CITY OF ALBUQUERQUE

April 30, 2010

**Re: West Mesa High School Parking Lot Grading and Drainage Plan
Engineer's Stamp dated 4-13-10 (J10/D005)**

Profile Report **Engineering Profile - MAIN LINE 1 (stormcad parking lot.stc)**

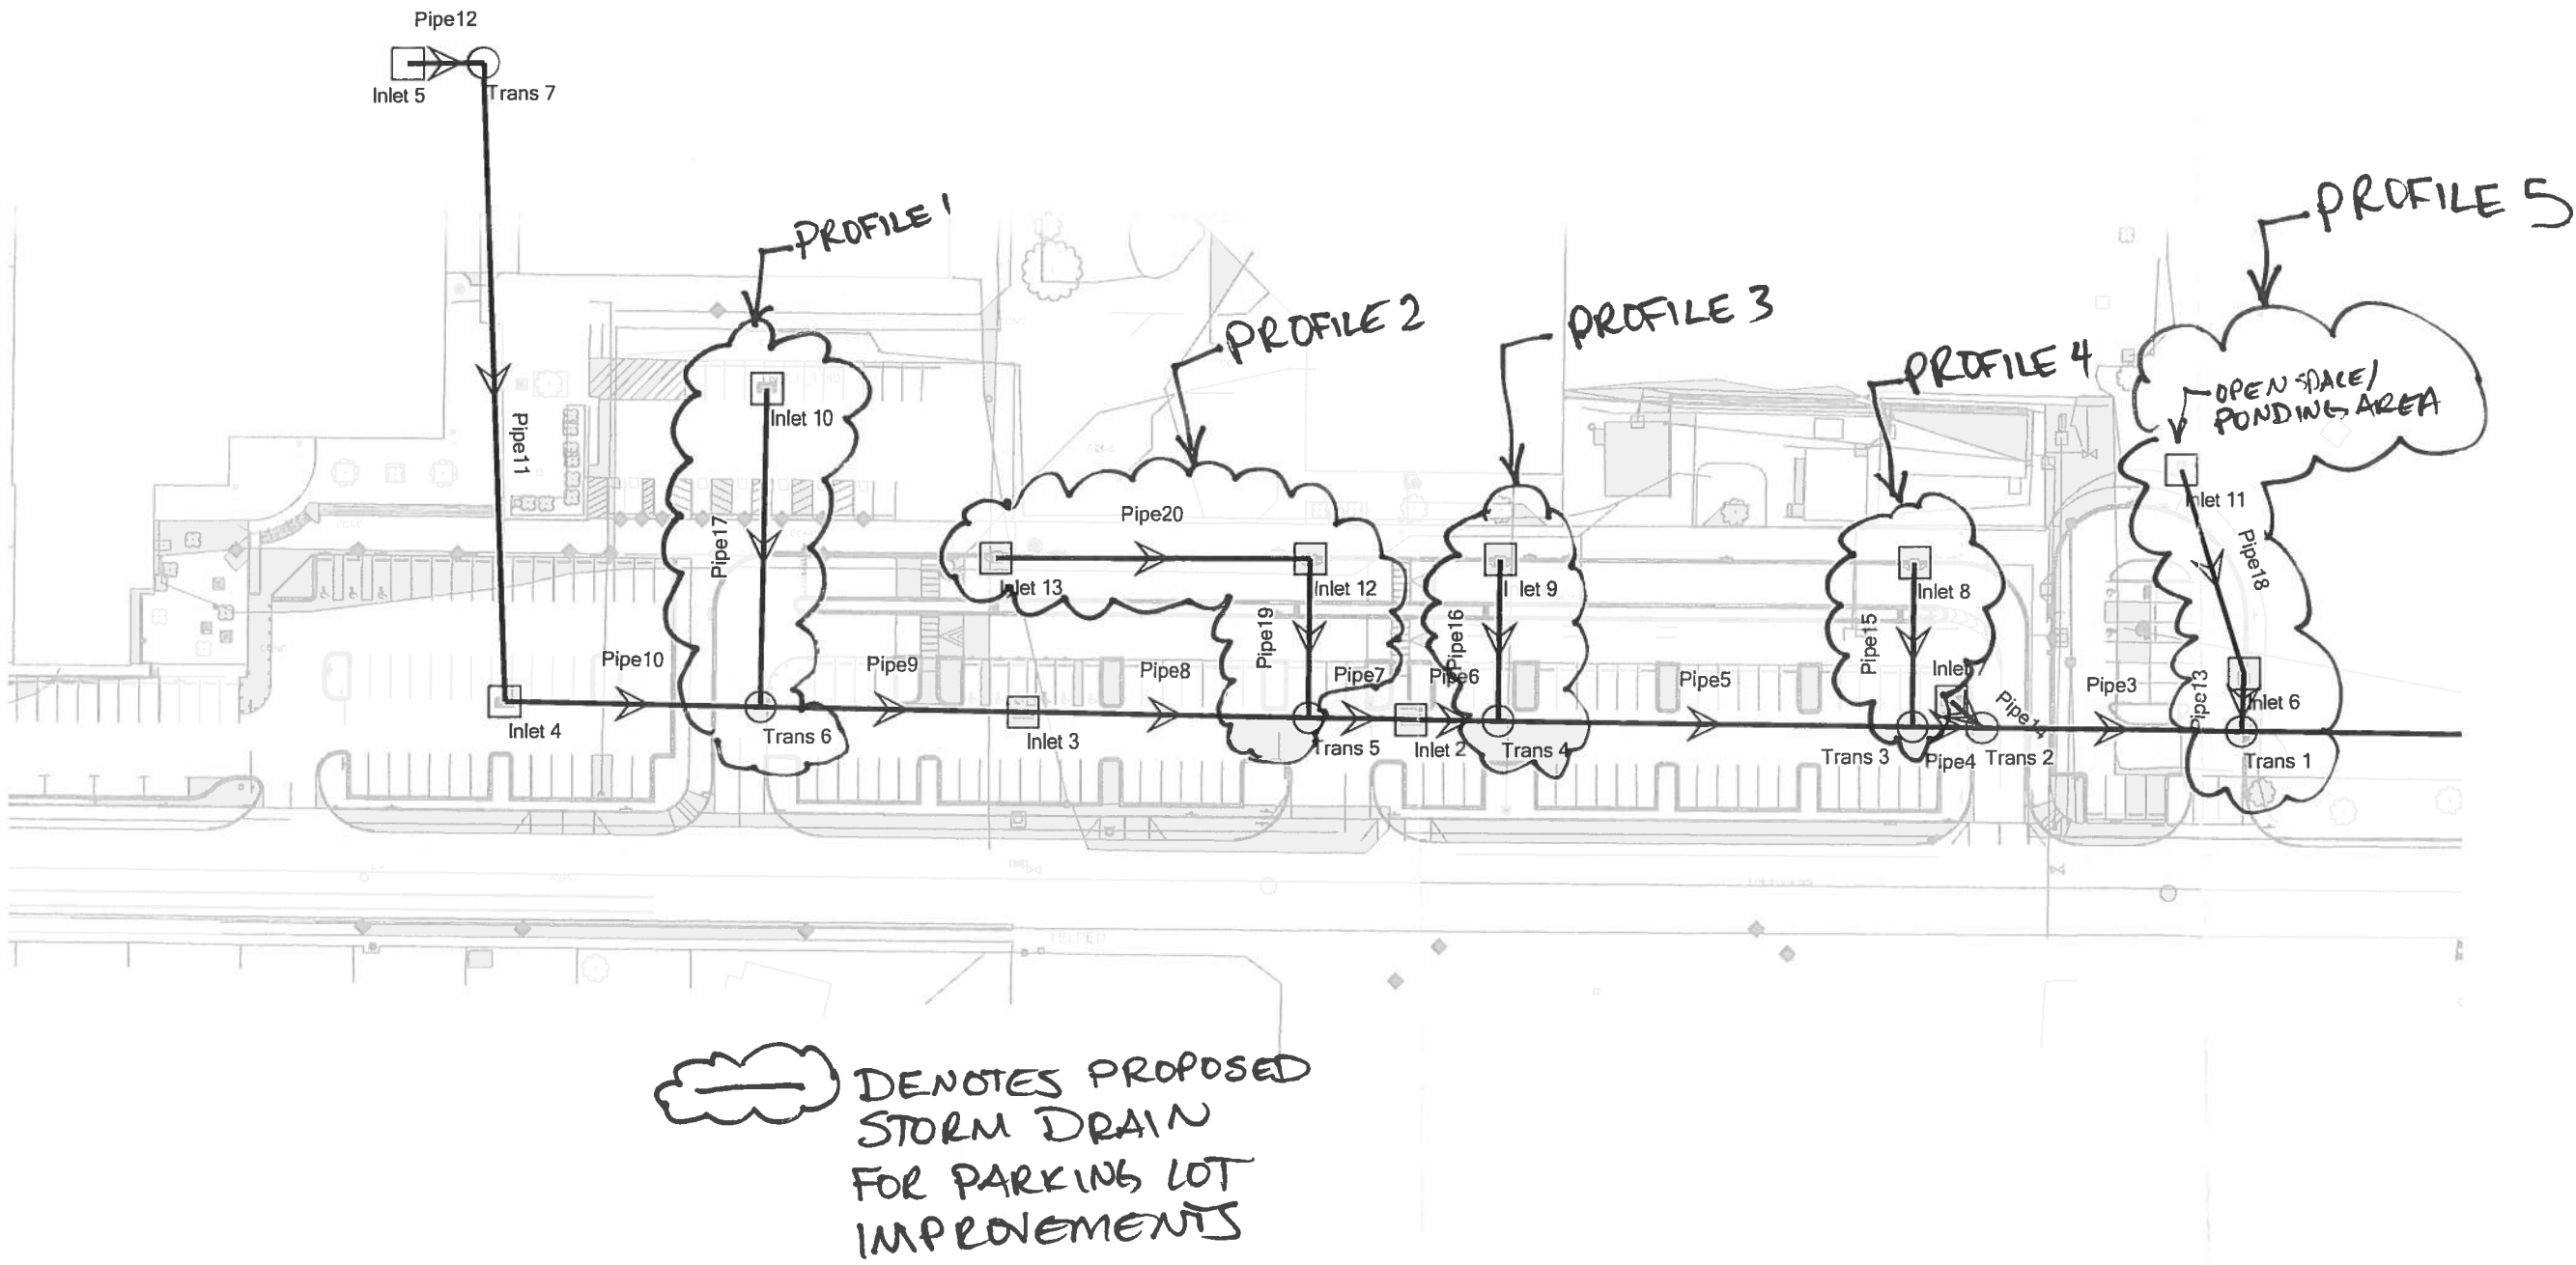
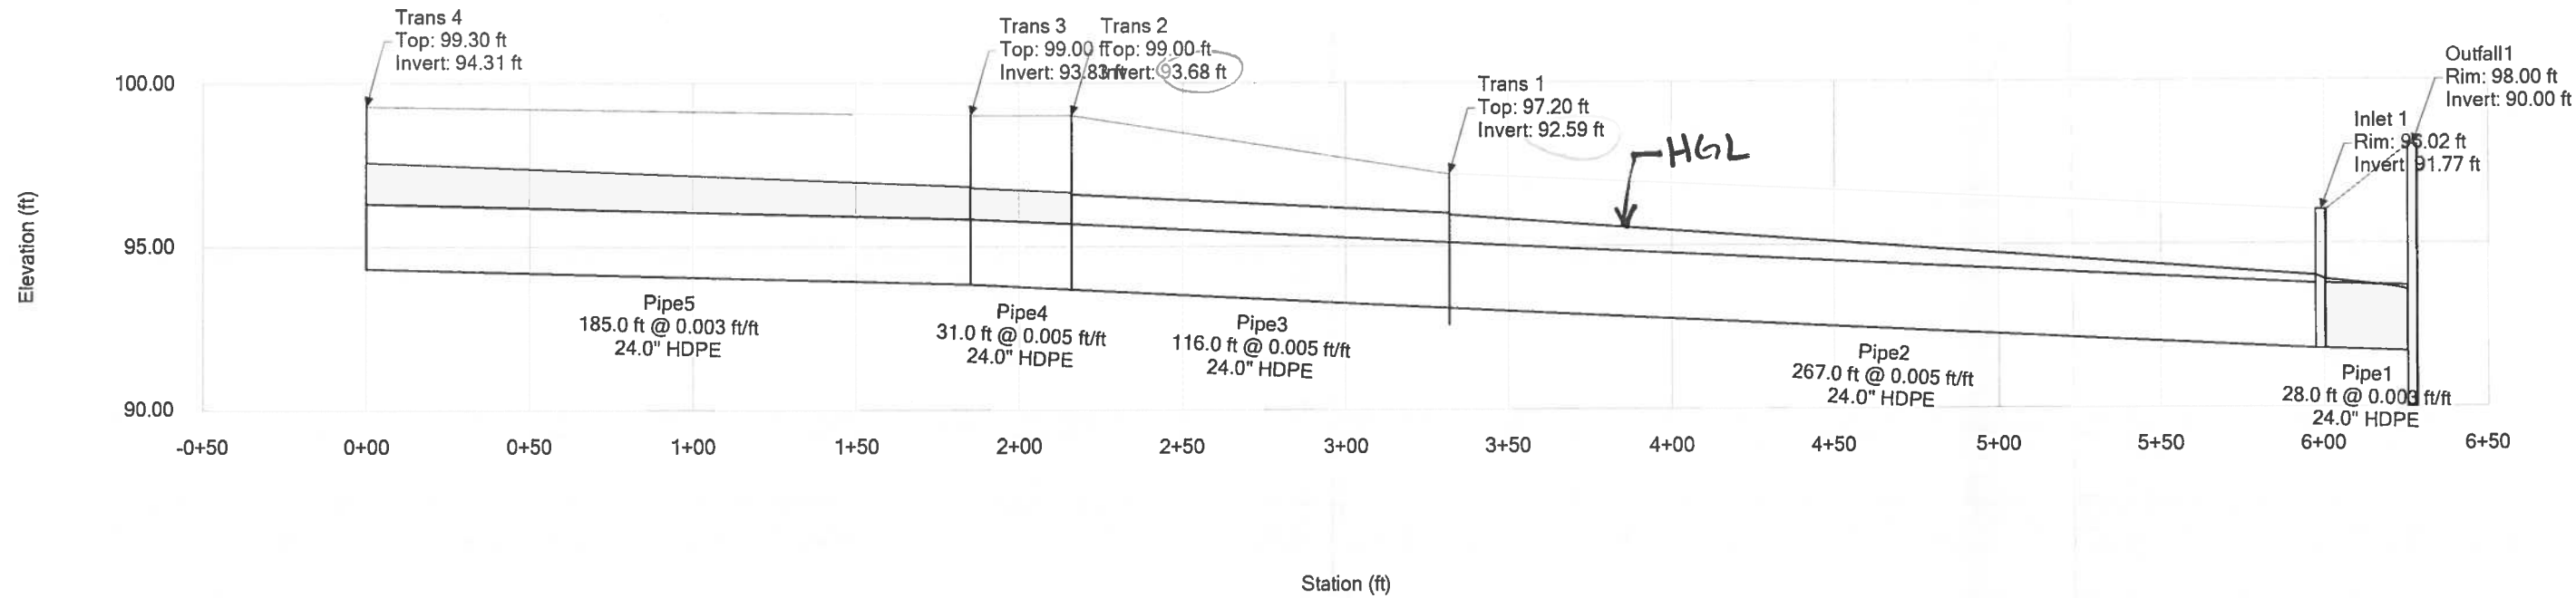
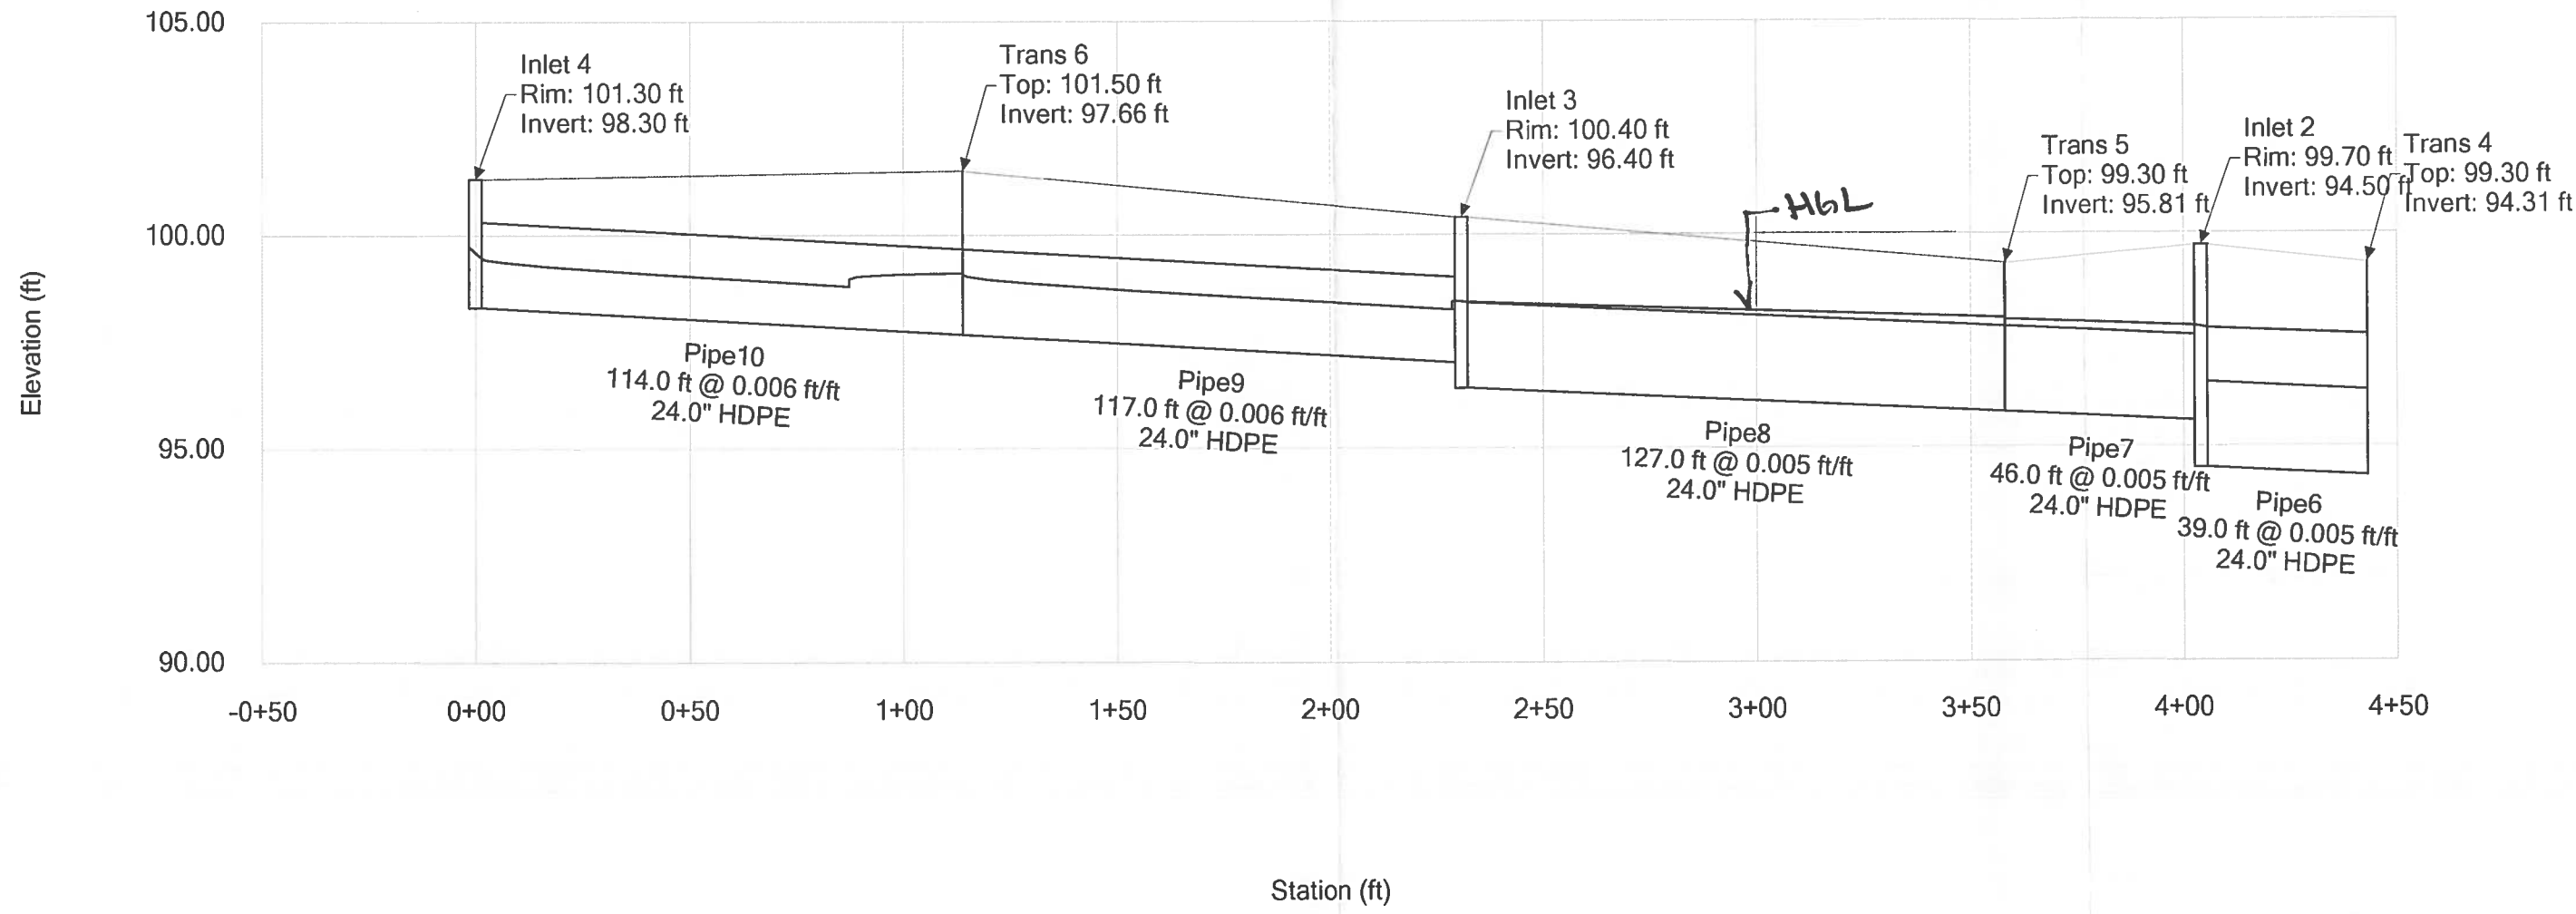
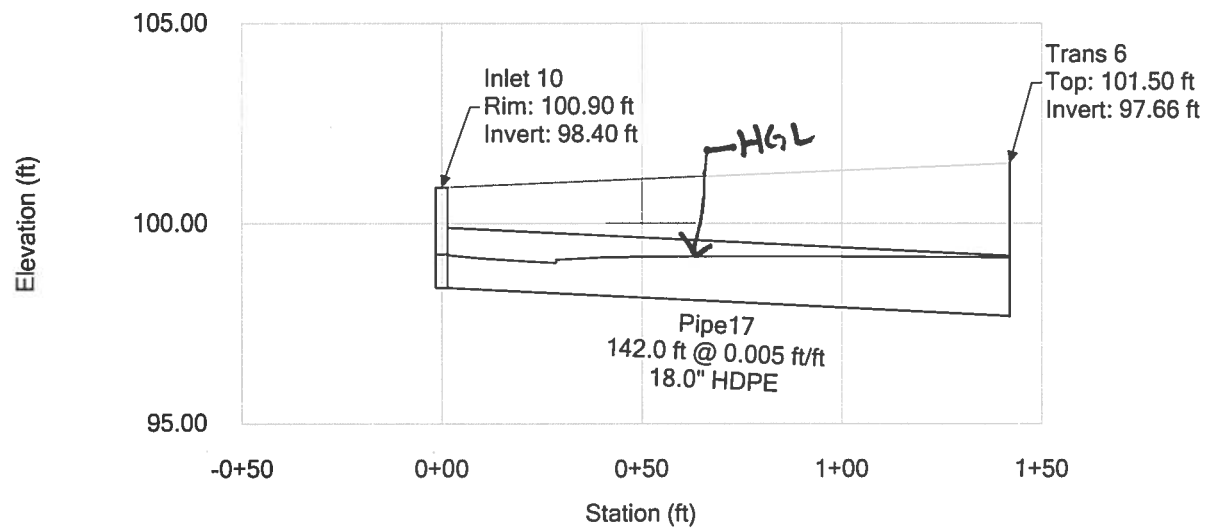
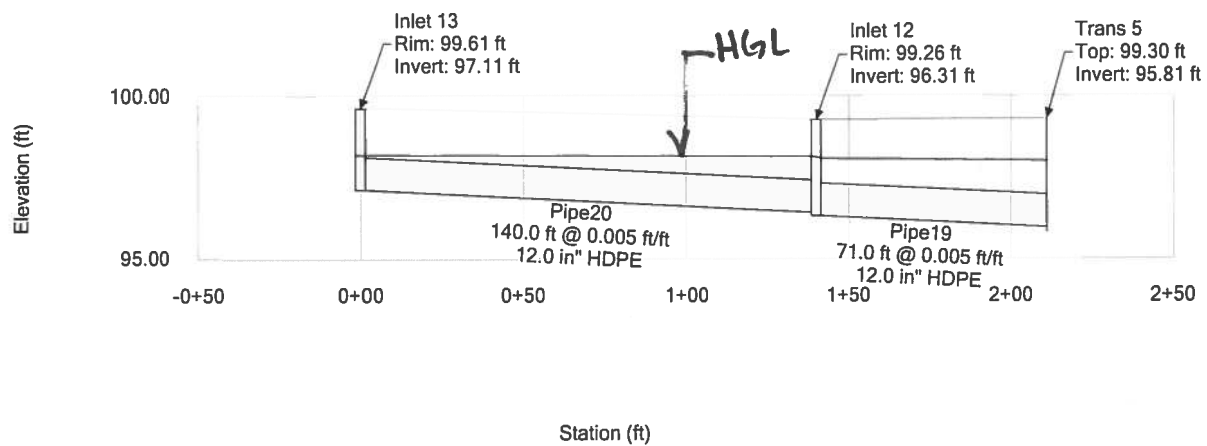
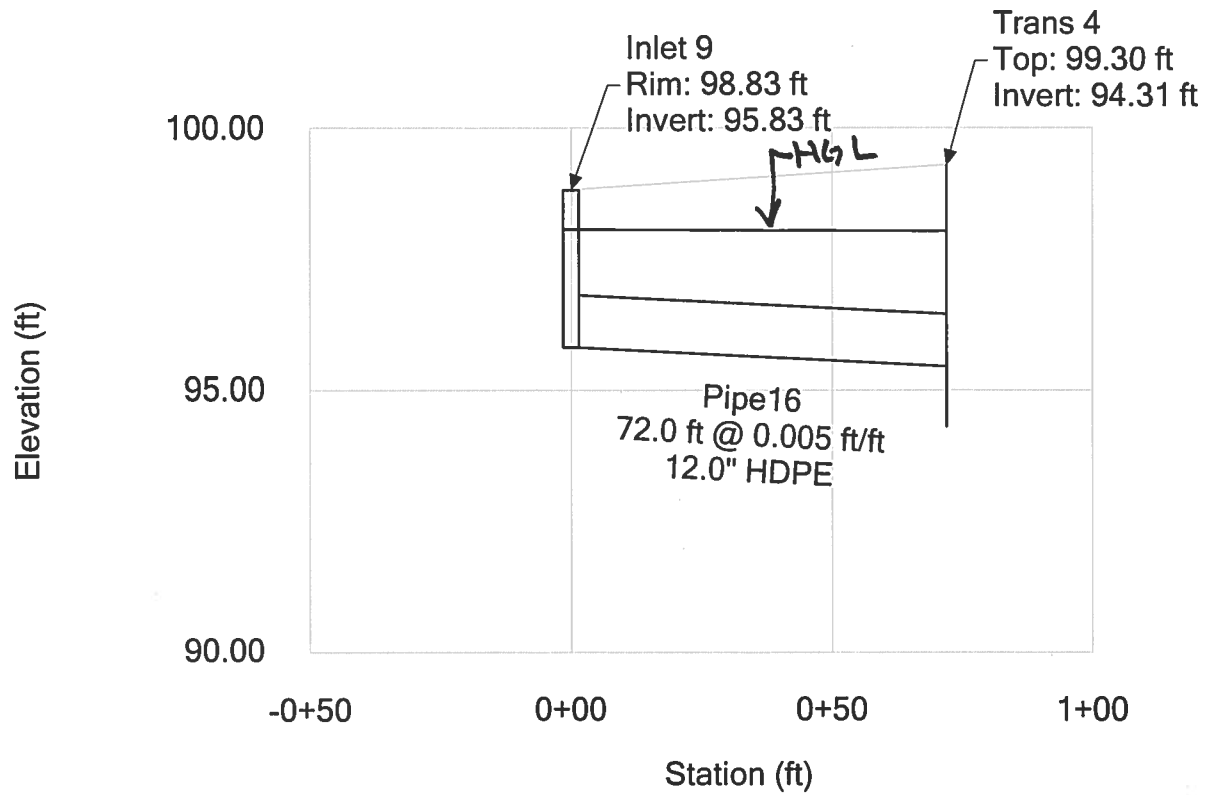
Please verify the inverts for the existing and proposed storm drain. There may be an inconsistency between the StormCad data and the Grading Plan.
